**Mt Arthur Coal Mine – Open Cut Extension (MP09_0062)
Water Management Plan**

I refer to the Water Management Plan (the plan), submitted in accordance with condition 29 of Schedule 3 of the development consent for the Mt Arthur Coal Open Cut Extension (MP09_0062).

The Secretary has approved the plan dated 10 December 2020, subject to the following amendments:

Figure 1: Surface Water Catchment Areas and Water Storages

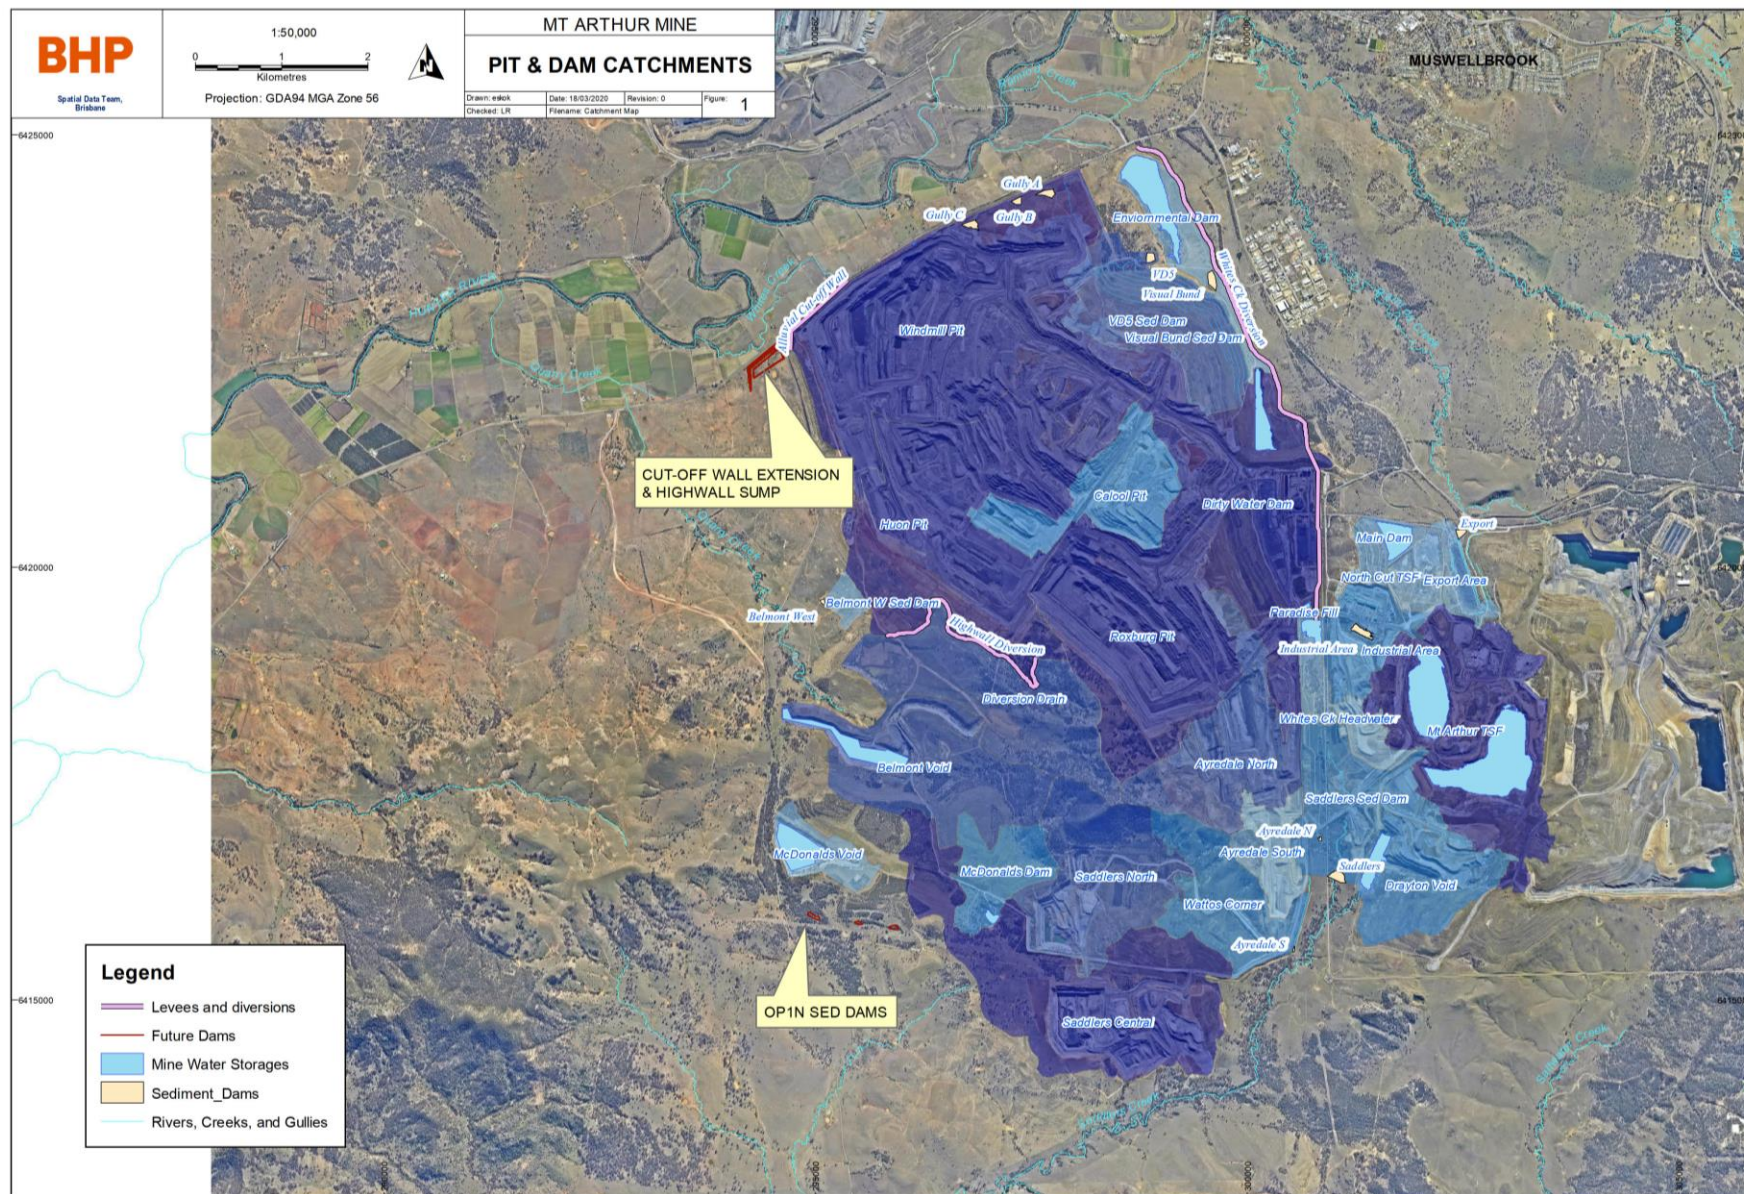
- in Section 8.3, replace “rehabilitate” with “rehabilitated” in the first dot point;
- in Section 8.3, add a legend/key to Figure 1;
- in Section 8.4, in the final sentence, replace “HRST” with “HRSTS” and “requirement” with “requirements”;
- in Section 9.3, replace “Guidance on Sampling of Groundwater’s” with “Guidance on the sampling of groundwaters”;
- in Section 9.1, add reference to the location of the baseline data within the document (i.e. Appendices 3, 5 and 6);
- in Section 11.2, replace “Ground Water” in the second dot point with “groundwater”; and
- ensure all references in the table in Appendix 8 are correct.
